From: Tom Wessely <[REDACTED]>
Sent: 02 September 2021 16:36
To: Simon Davis
Cc: David West; Andy Mckeown-Mundy; Ian Johnson
Subject: Re: Condition 5 ref. Y/97/21/DOC
Attachments: Plots 1.2.3.20.21 _ Elevations.zip

Client						
Job title	Bonhams Field Yapton West Sussex					
Drawing title	General Arrangement Elevations Plot 3					
Drawn	Date	Checked	Date	Scale at A1		
GW	28.06.21			1:50		
Job No.	Pro.	Org.	Zone	Level	Type	Role
20-202	BHF	MHA	00	ZZ	DR	A
Purpose of issue				Z012		
				C02

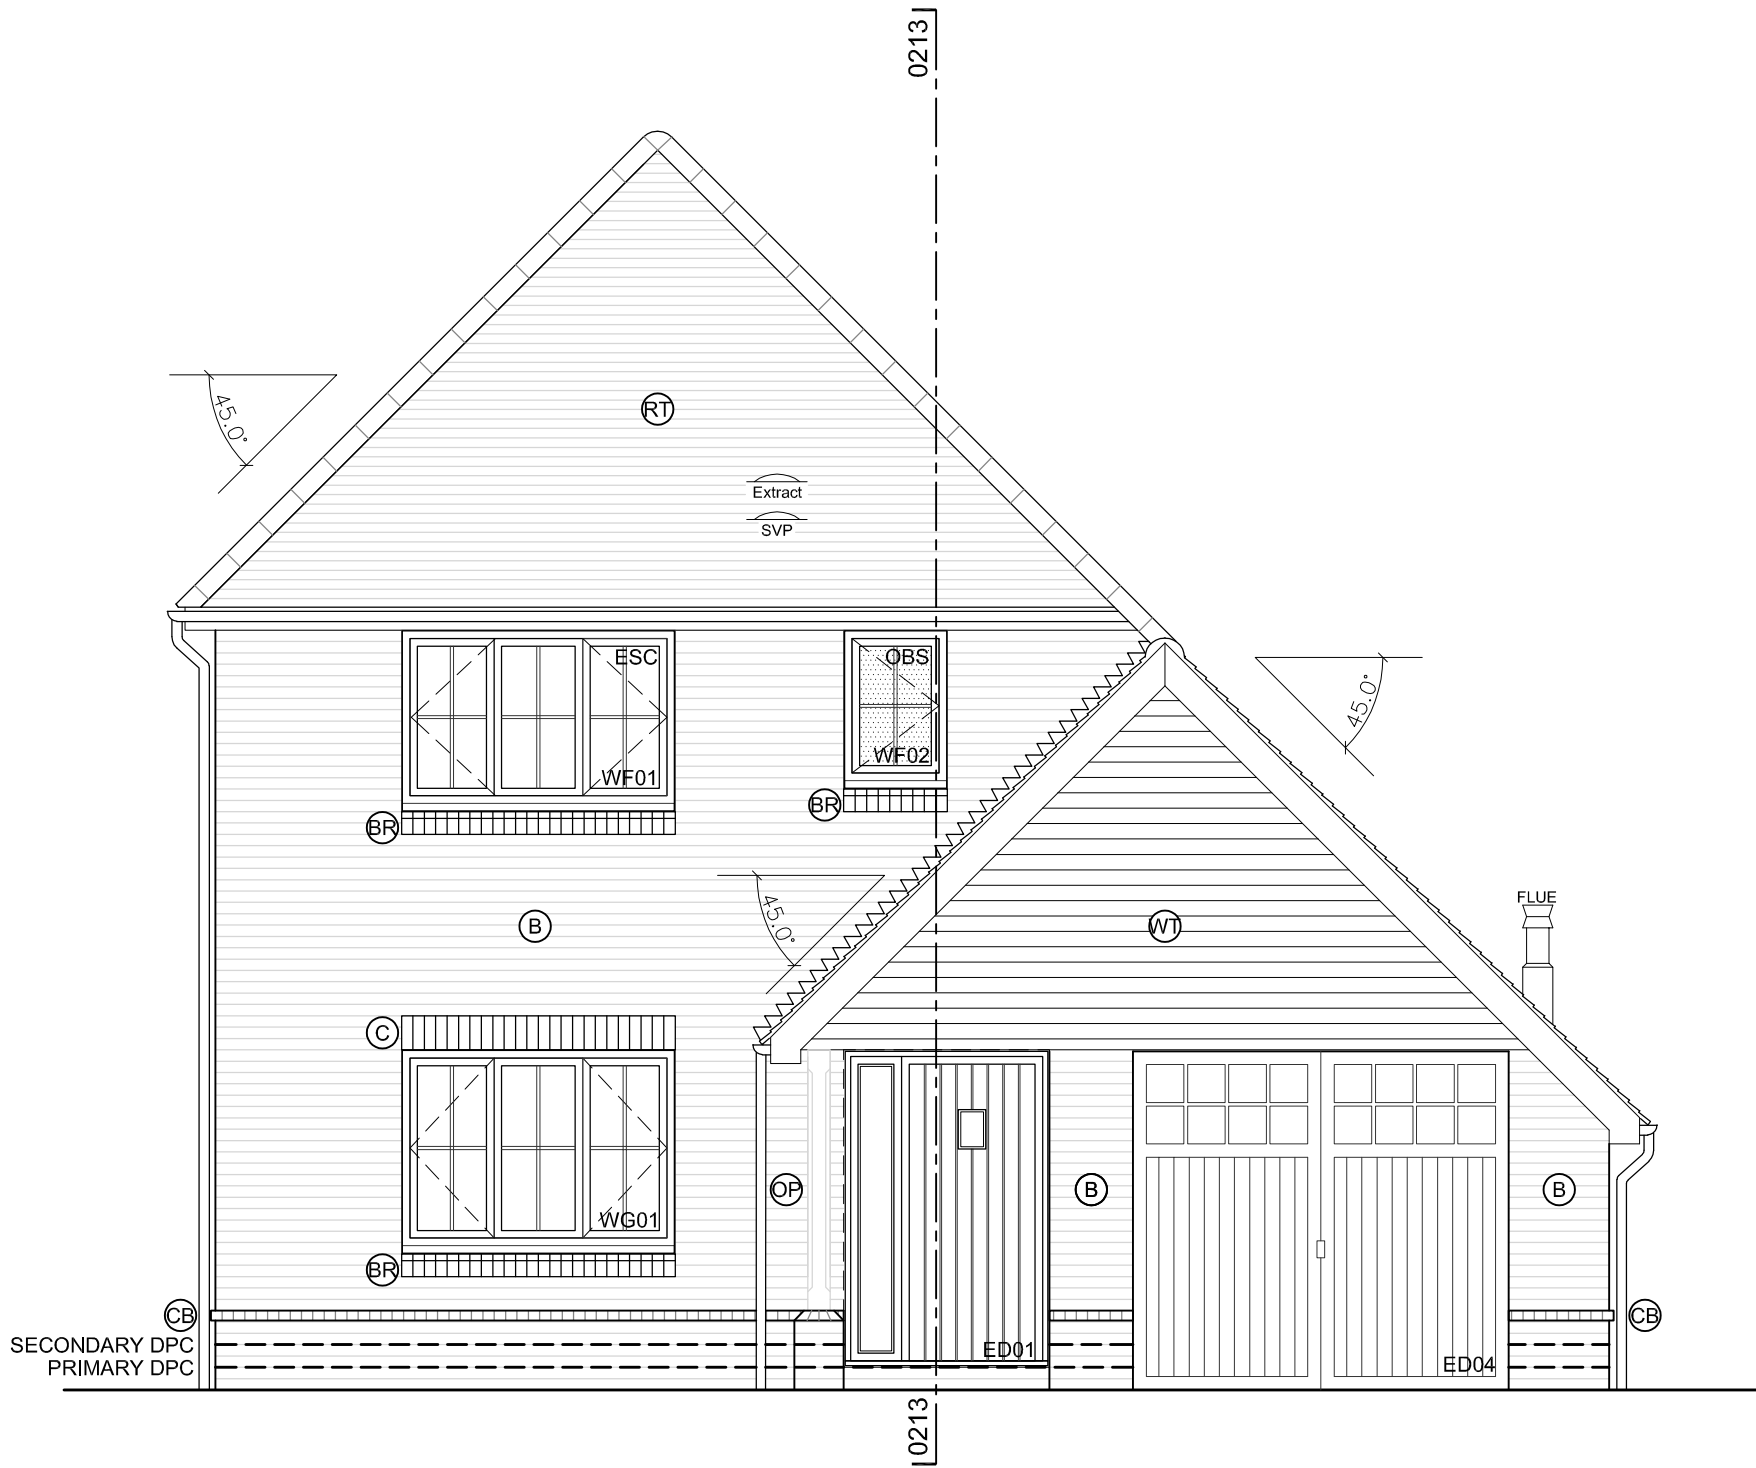
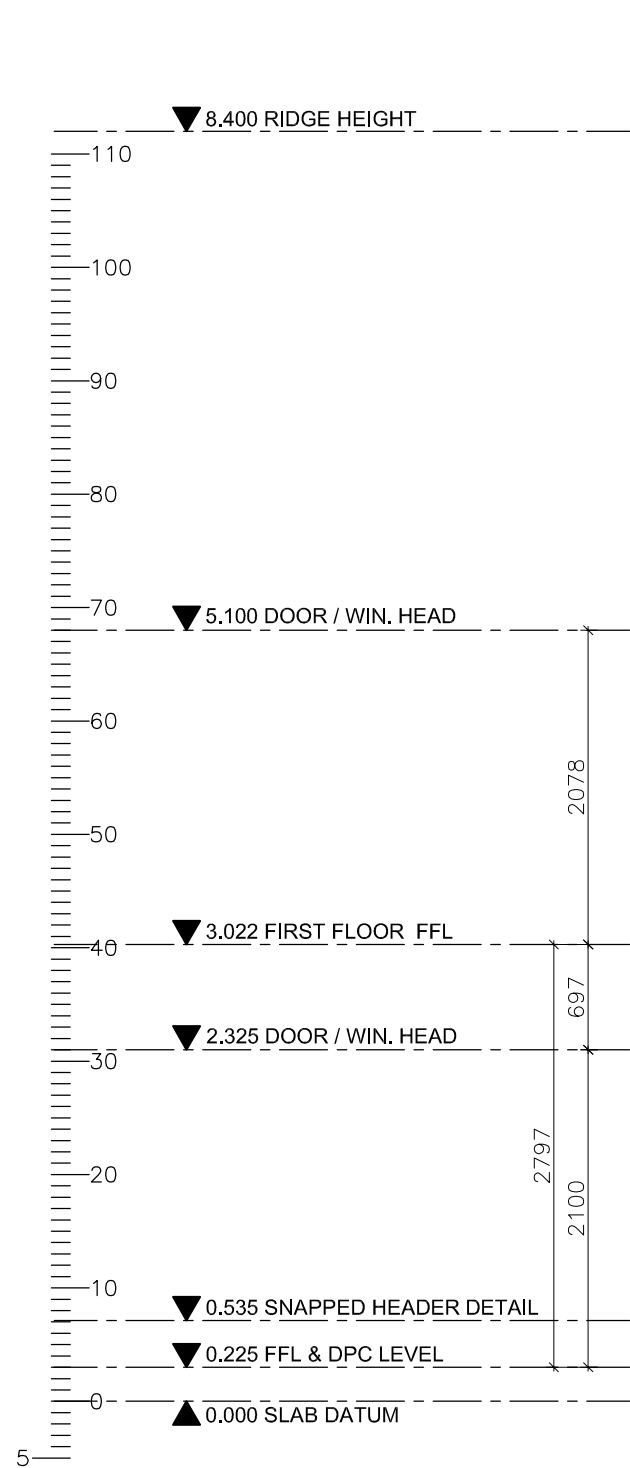
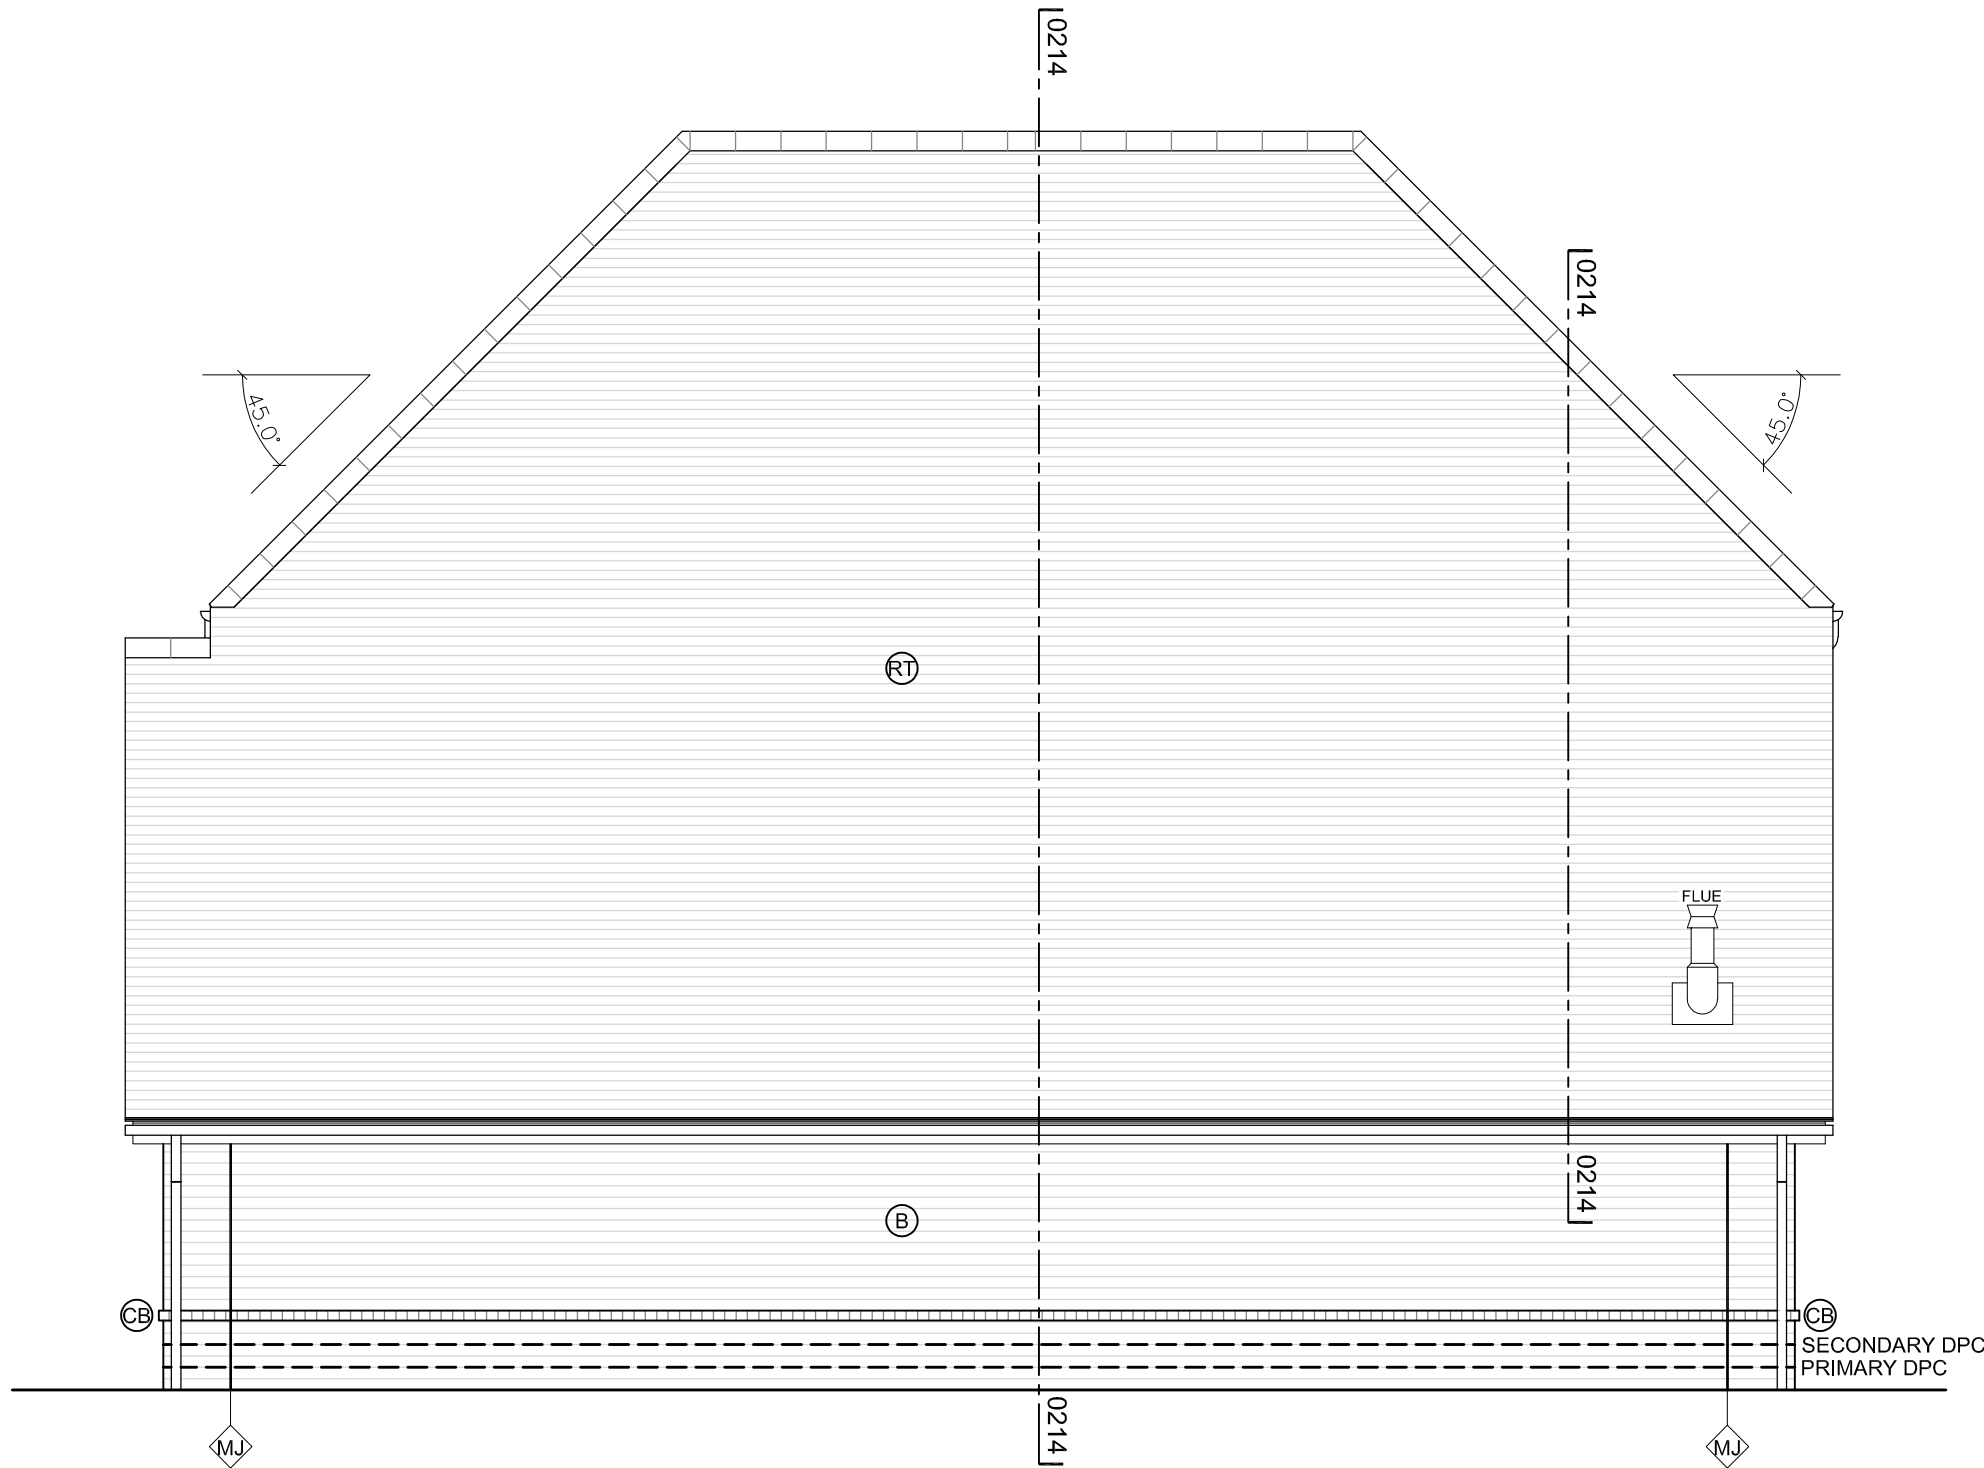
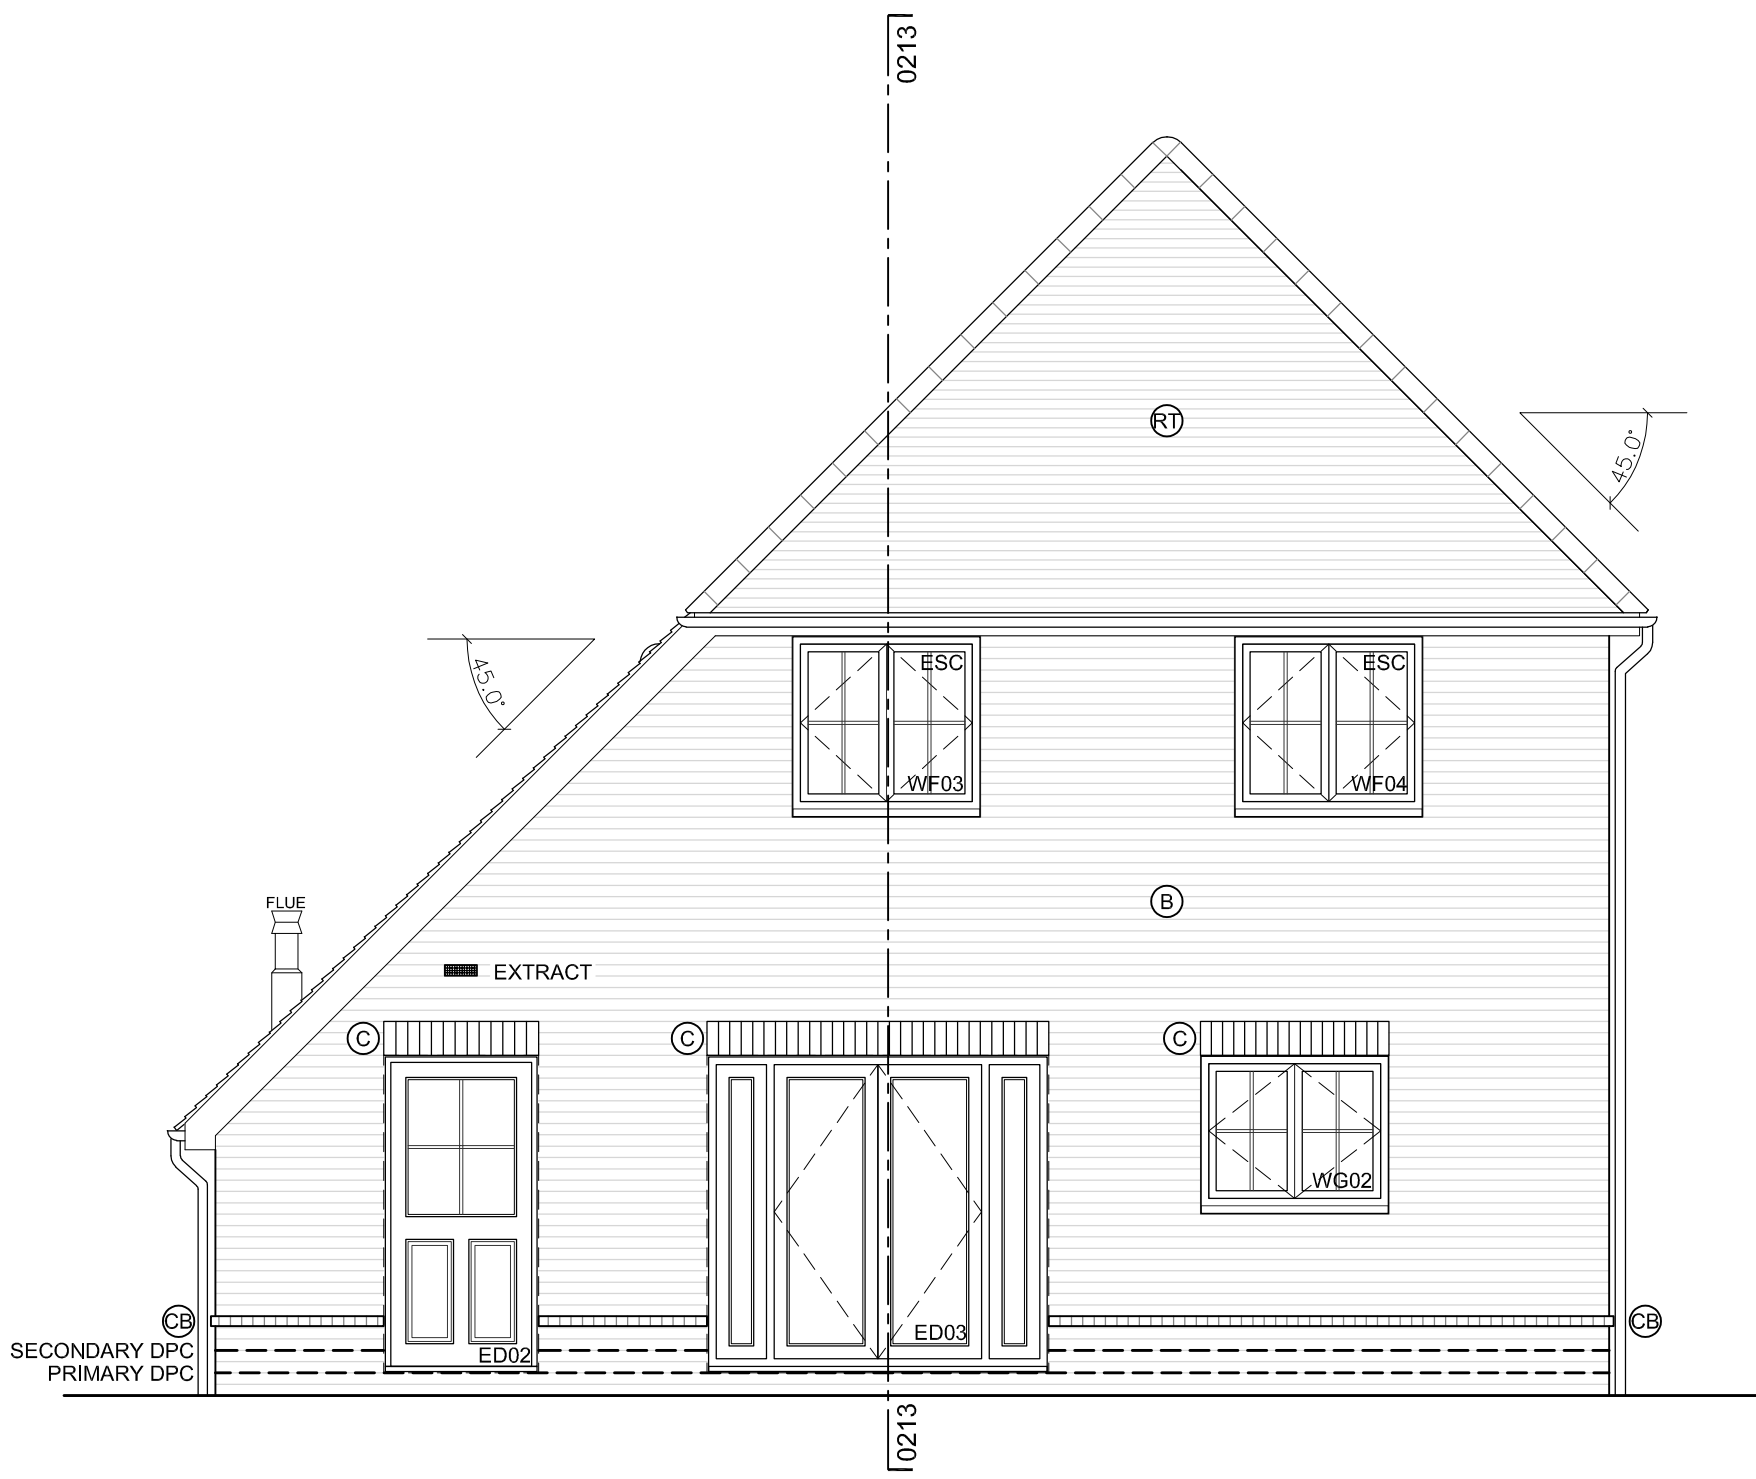
Secondly, we have no plans referring specifically to plots 1, 2, 3 and 19-21 which are named in the condition. Can you advise the position in respect of these? Are they covered by the above plans? If they are then its not clear from the drawings.

Please see enclosed elevations for plots 1, 2, 3, 20 and 21. I am not in a position to provide you with the drawing for plot 19, however I can confirm that this plot will also have white painted timber windows.
